Fire Risk Assessment

Owner/responsible person	Isle of Bute jewellery Ltd	Address of premises audited	Flat 5 Boak Place, Inverkip. PA16 0AT
Date of assessment	07/07/2023	Assessor	Kenny McGillivray Argyll Safety Consultants
Premises (brief description)	First floor flat in 3 storey block of flats consisting of Entrance to hallway, 1 bedroom, lounge, kitchen and shower room. There is a small hall storage cupboard.

Inverkip Fire Layout

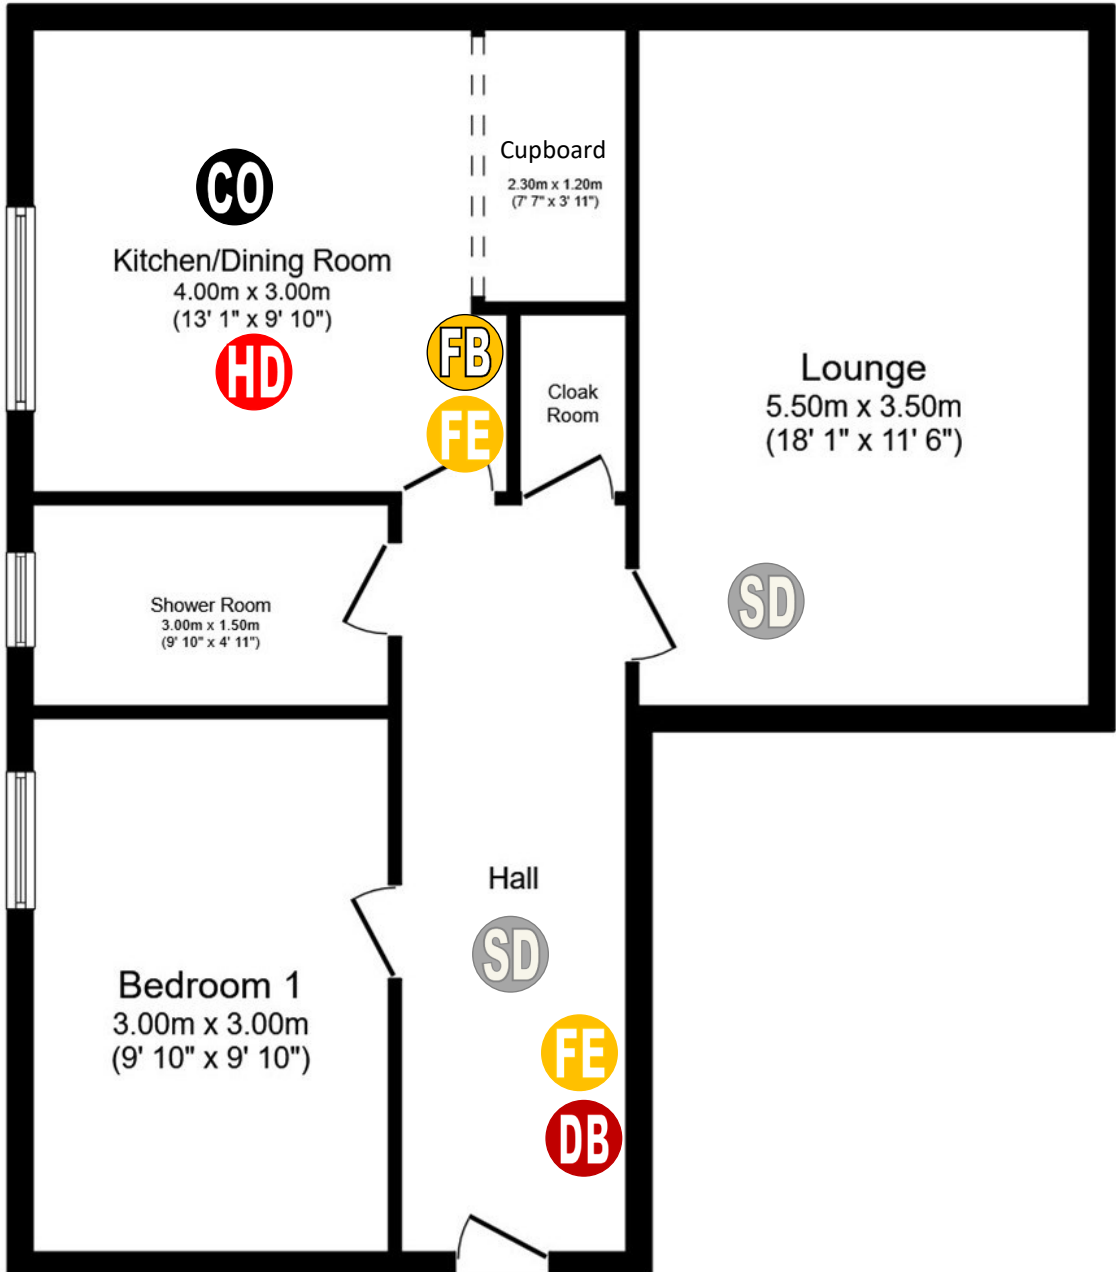
Yes No NA	Risk (L/M/H)	Observations (include existing controls)	Control Measures Required	Date to be completed	Actioned by and signed when completed
1. Can all occupants easily escape from fire?	N	H	Beds set in kitchen cupboard with no escape in event of kitchen fire	Remove beds and sleeping facilities from this kitchen cupboard.	immediately	
2. Can a place of safety be reached within 2/3 minutes from all areas?	N	H	As above			
3. Do all escape routes lead to a place of safety?	N	H	As above			
4. Are escape routes free from combustible materials?	Y	L				
5. Are all escape routes unobstructed?	Y	L				
6. Are escape routes of sufficient width?	N	H	As noted above regarding kitchen cupboard used for sleeping

Yes No NA	Risk (L/M/H)	Observations (include existing controls)	Control Measures Required	Date to be completed	Actioned by and signed when completed
1. Are fire extinguishers provided?	N	H	No fire fighting equipment in place	Install fire fighting equipment and ensure fire extinguishers and blanket serviced annually as per BS5306. Install 1x multi chem and 1 x blanket	30/08/2023 annually	
2. Are fire blankets provided?	N	H	See above			
3. Is a sprinkler system installed?	N	L				
4. Is the fire fighting equipment sited correctly?	N	L				
5. Is there a fire suppressant system installed?	N	L				
6. Is the fire fighting equipment visible or signed?	N	L

No detection in cupboard where main electrics sited. Consider installing detection in mains cupboard		30/08/2023	
6. Fire fighting equipment	Install fire fighting equipment and ensure fire extinguishers and blanket serviced annually as per BS5306. Install 1x multi chem and 1 x blanket		30/08/2023 & Annually	
7. Management of Fire Safety	Beds set in kitchen cupboard with no escape in event of kitchen fire - Remove beds and sleeping facilities from this kitchen cupboard.		immediately	
	Develop fire emergency plan and/or install fire action notice in kitchen Ensure guests are advised in an emergency plan/notice to leave keys in doors at night. An assembly point should be noted on the emergency plan		30/08/2023	
First Review Date	Review as actions completed and signed off	To be completed by	Owners/responsible persons	
Notes
